June 8, 2026

Revised: August 19, 2026

Subject: Response to Review Comments
Geologic Hazards Evaluation and Preliminary Geotechnical Investigation
Mayberry, 540 Acre Site, PUD2
Highway 94 and Log Road
El Paso County, Colorado
CTL|T Project No. CS18969.004-105-L1 Rev

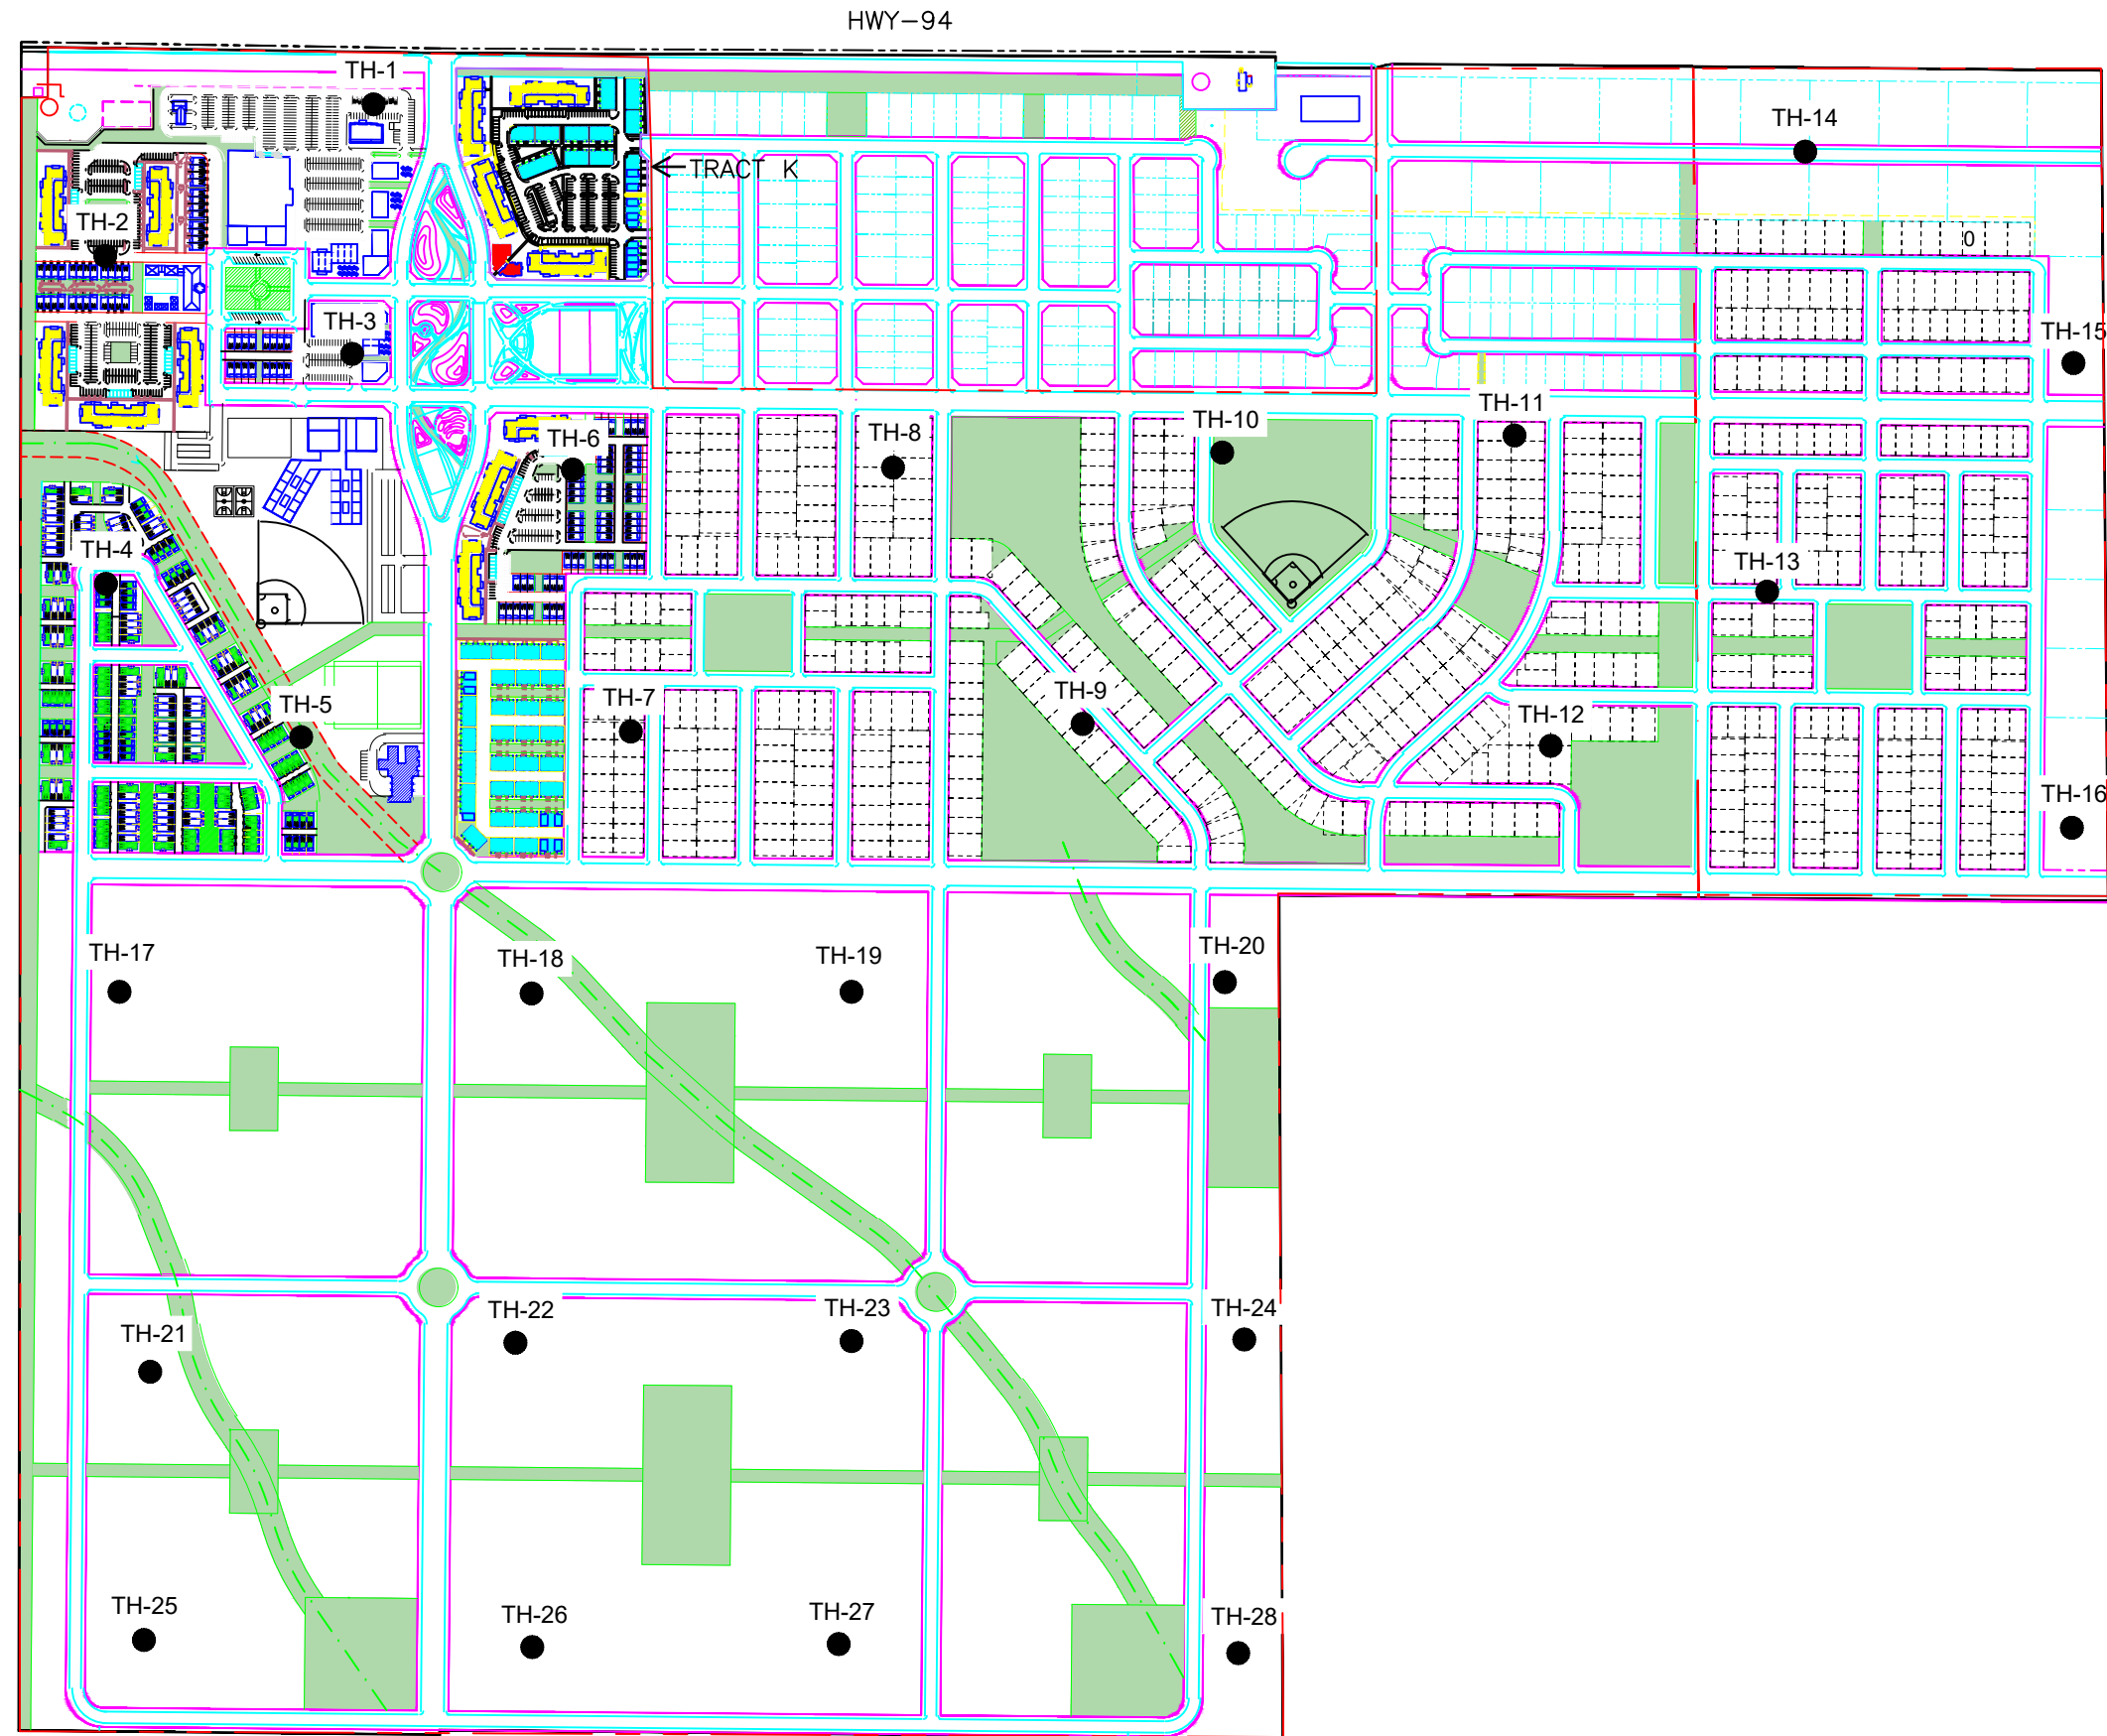
And October 2025 Review Comment in blue text box on Fig. 1 of our report:

"Call out the specific project area for Mayberry PUD 2 with a boundary"

PUD2 is a part of the 540-Acre Site, which is covered by this report. We have revised Figure 1 to include a boundary for PUD2 and we have added a Figure 2, which is a detail of the PUD2 area from Figure 1, since the PUD2 area is relatively small compared to the overall 540 Acre site.
